**RE: 100 EDINBURGH ROAD, CASTLECRAG
DRP No. 2 MONDAY 2nd FEBRUARY 2026
DESIGN ADVICE LETTER**

As you may be aware, the second Design Review Panel (DRP) meeting was held in relation to a HDA SSDA at the abovementioned site on 2 February 2026. This correspondence represents the Design Review Panel's Design Advice Letter following the DRP of 2 February 2026.

Figure 40: Indicative Master Plan for Castlecrag.

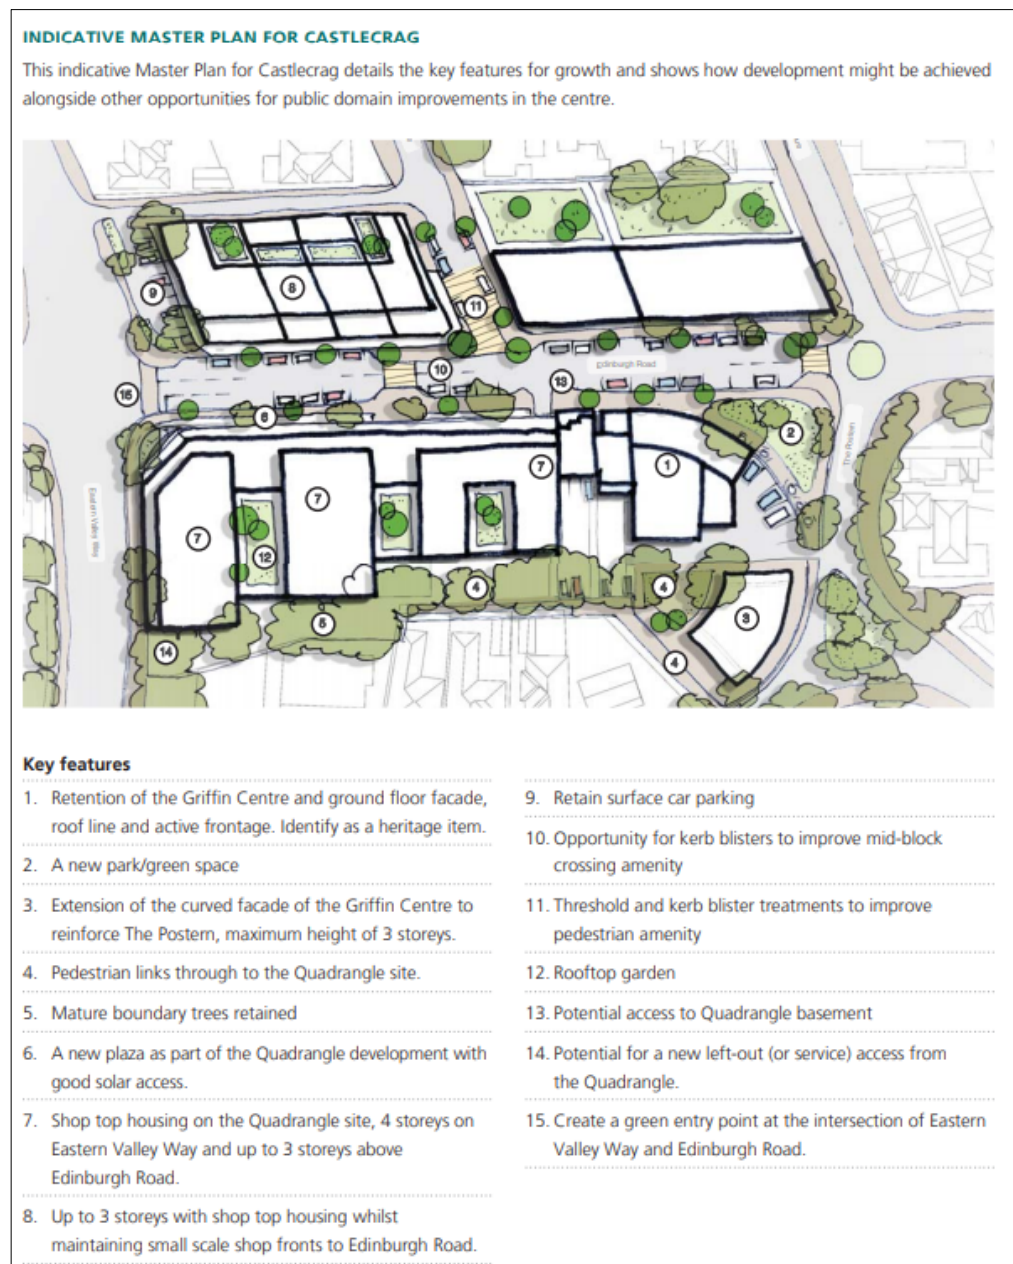
- The Panel acknowledges this is an HDA application and therefore supersedes local controls. However, it notes that the "Indicative Master Plan for Castlecrag" in the "Willoughby Local Centres Plan 2036," referred to in Weir Phillips' Heritage Impact statement, indicates a development potential of 3 storeys to Edinburgh Road the 4 storeys at the corner of Eastern Valley Way. These heights are consistent with the current approved plans.
